Our ref: HE551507-MMSJV-LSI-000-CO-UU-0002

Infrastructure Planning (Examination Procedure) Rules 2010 – Request by the Examining Authority for further information under Rule 17

Application Ref TR010036 - A303 Sparkford to Ilchester dualling scheme

I refer to the Examining Authority's letter dated 11 March 2019, requesting further information in relation to our application to make a material change to our application for a Development Consent Order.

C:\users\pas44049\dms44322\HE551507-MMSJV-LSI-000-DR-UU-2033.dwg Apr 3, 2019 - 9:59AM PAS44049

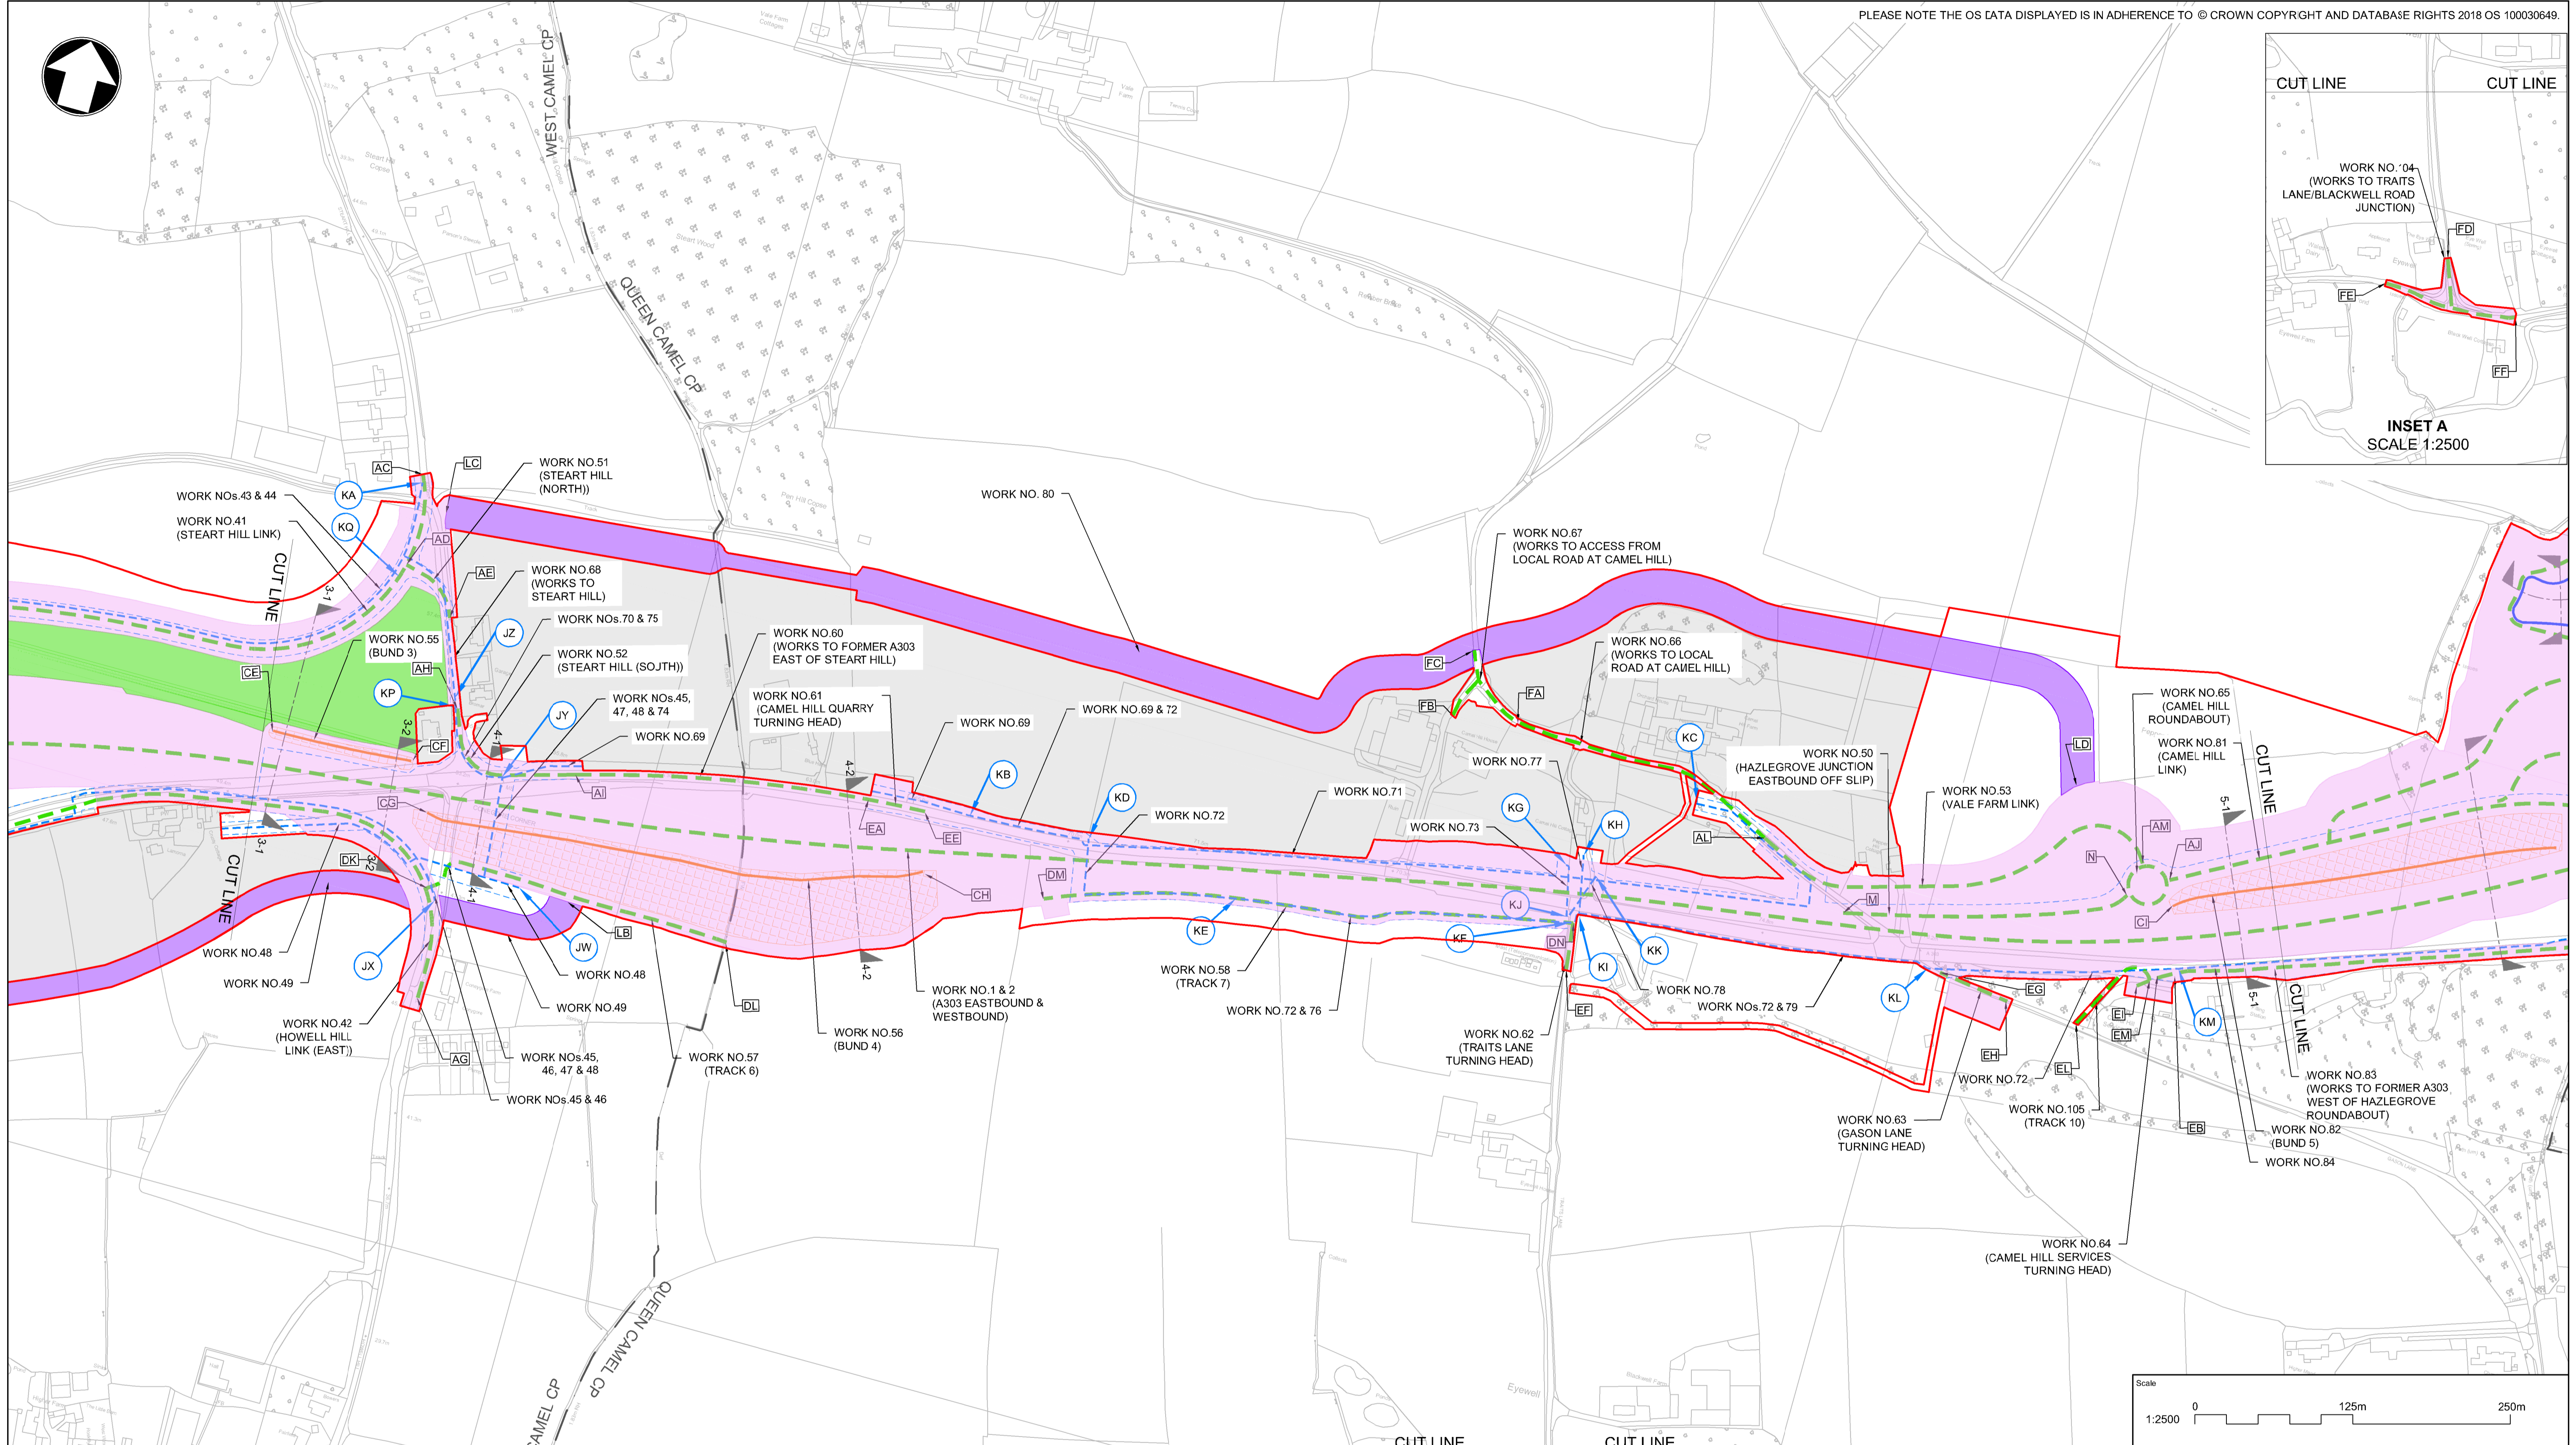
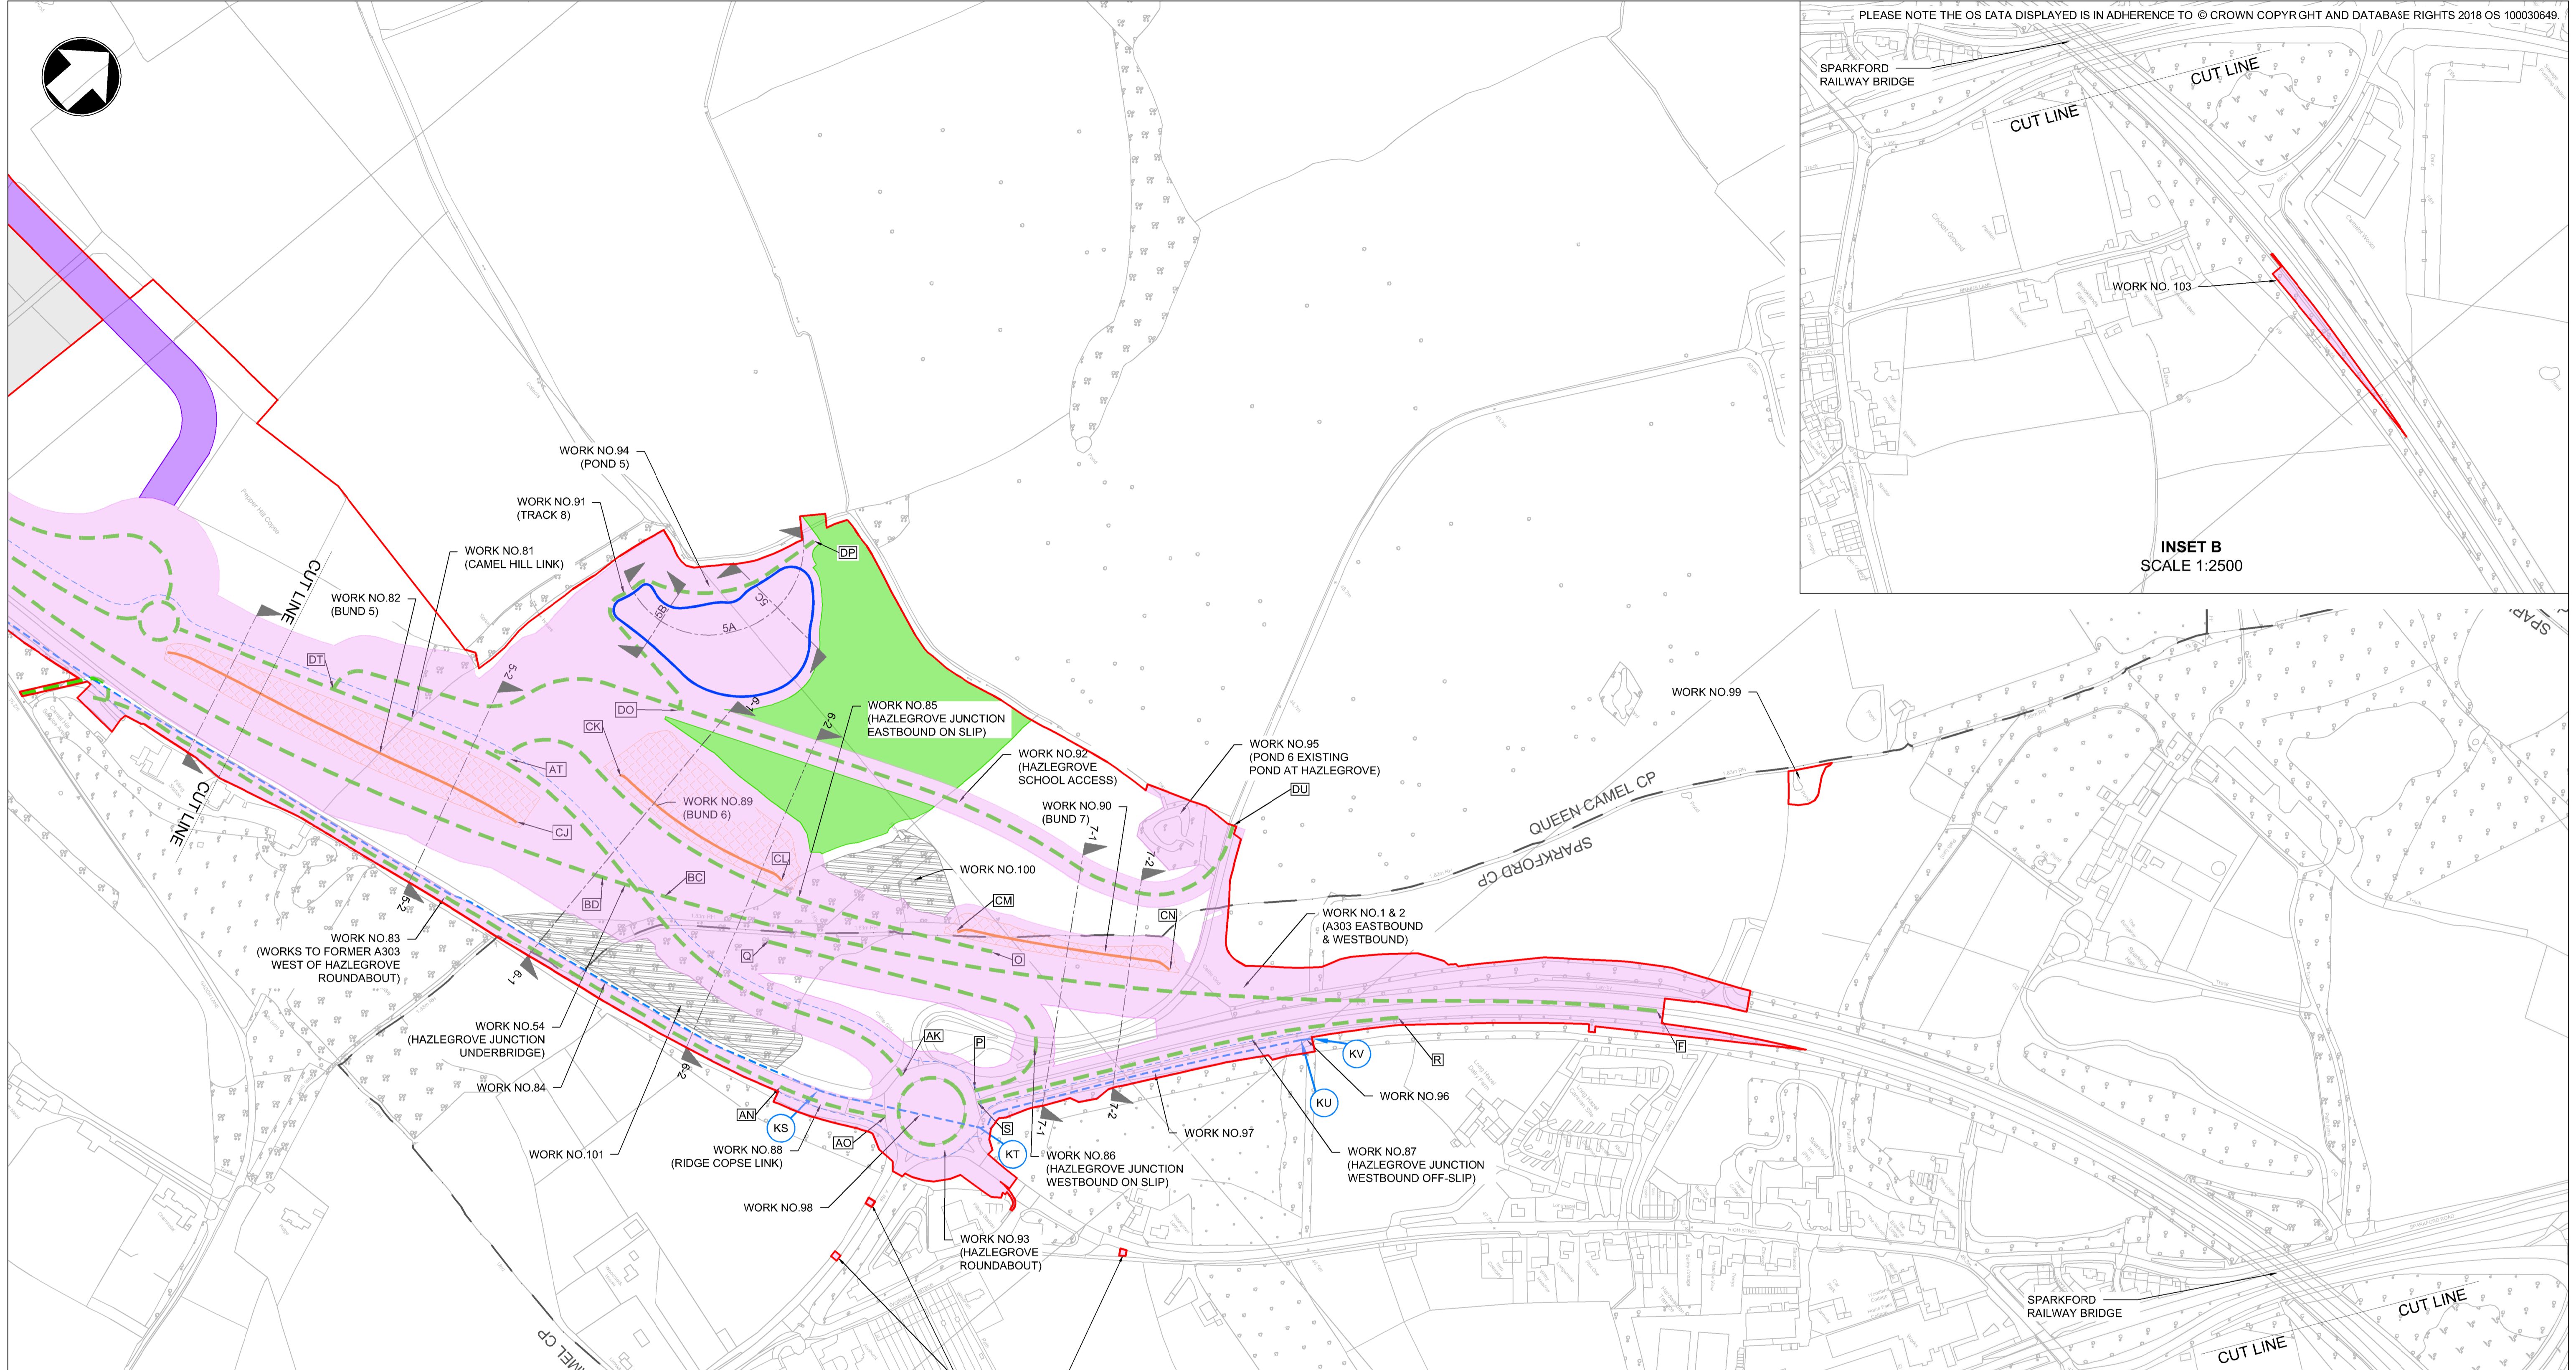
For the avoidance of doubt, the Applicant requests that as part of this material change request, Work Number 59 is removed from the Application, which was for the proposed construction of an accommodation track for Blackwell Farm between points DR and DS.

The Applicant requests that Work Number 104 is included within the Application, which is the proposed widening of the carriageway of the public highway at the junction between Traits Lane and Blackwell Road.
